NSW RURAL FIRE SERVICE

Your Ref: MP 05_0129 Mod 3

Our Ref: DA-2009-07893-S4.55-1

Development Application; Section 4.55 (1A) Modification of Consent MP 05_0129 to Stage 3A, Lot 10 DP 1240161, The Lakes Estate Residential Subdivision, North Boambee Valley, Coffs Harbour City Council Local Government Area.

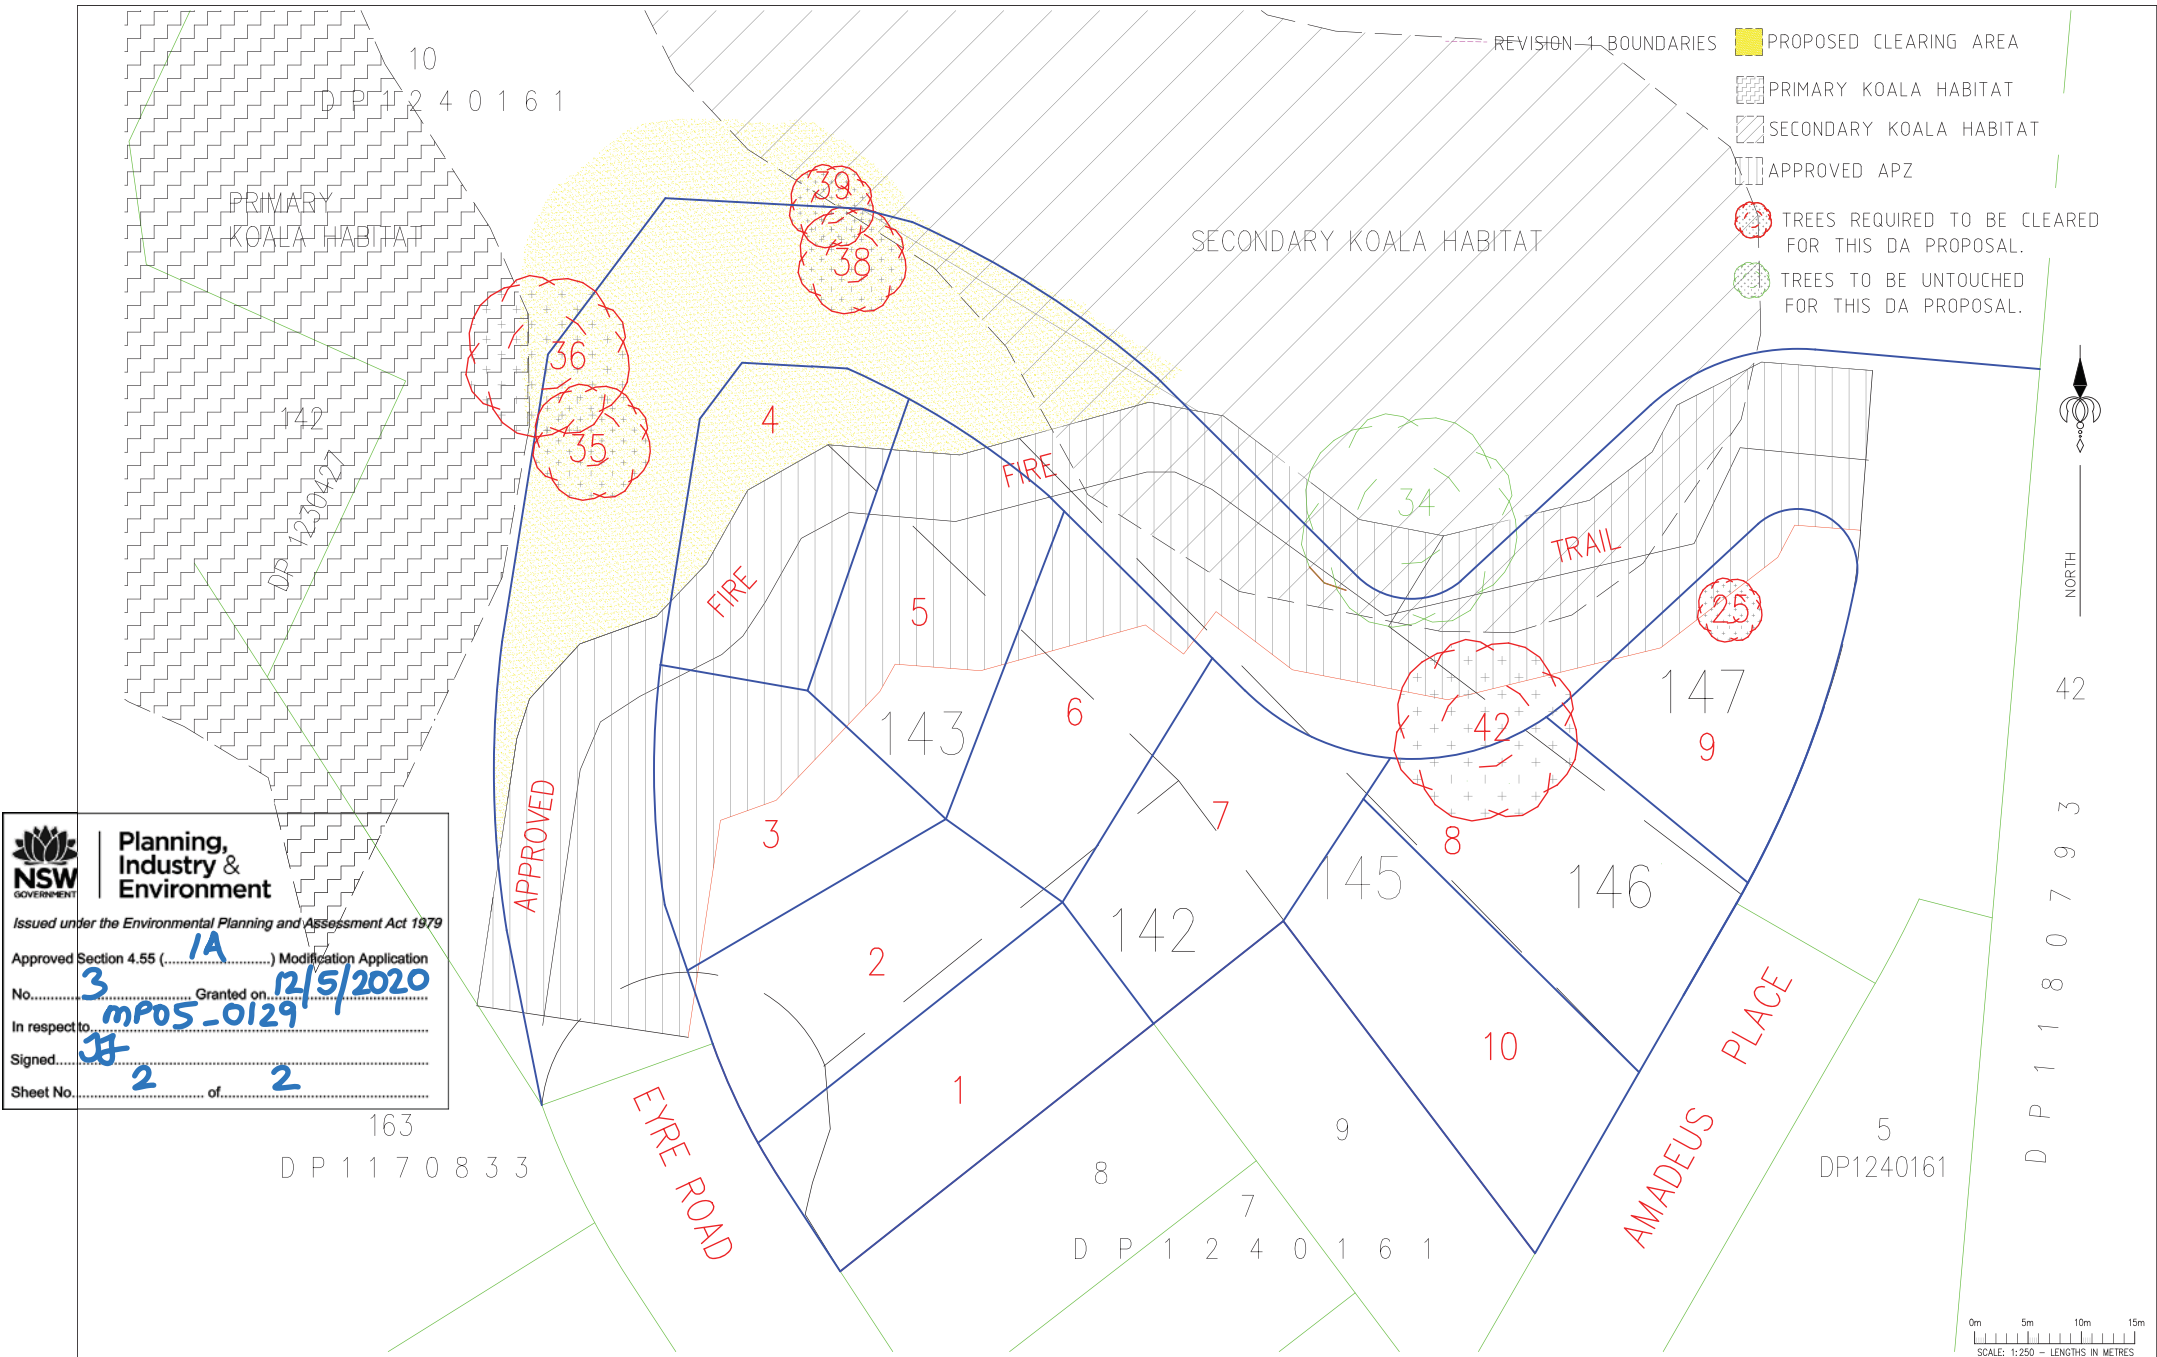
1. The following comments are based on the plan; prepared by Newnham Karl Weir titled "Proposed Subdivision Lot 10 DP 1240161 Road, Drainage Works, Water Supply & Sewerage" and dated 14/10/19.

2. At the issue of a subdivision certificate, all Stage 3A lots (Proposed lots 1 - 10) must be managed as an inner protection area (IPA). The IPA must comprise:

3. At the issue of a subdivision certificate, a suitable mechanism, such as an instrument pursuant to section 88 of the 'Conveyancing Act 1919', must be in place over proposed lots 1 - 9 to ensure future dwellings are not erected within the required APZ. The APZ is shown on the drawing; prepared by Building Code & Bushfire Hazard Solutions P/L titled "The Lakes Estate Stage 3A (ii) Bushfire APZ Overlay", dated 28/10/19 and found as an attachment to their Bush Fire Assessment Report of 28/10/19.
The name of authority empowered to release, vary or modify any instrument shall be Coffs Harbour City Council.

4. Public road access shall comply with the requirements of section 4.1.3 (1) of 'Planning for Bush Fire Protection 2006'.
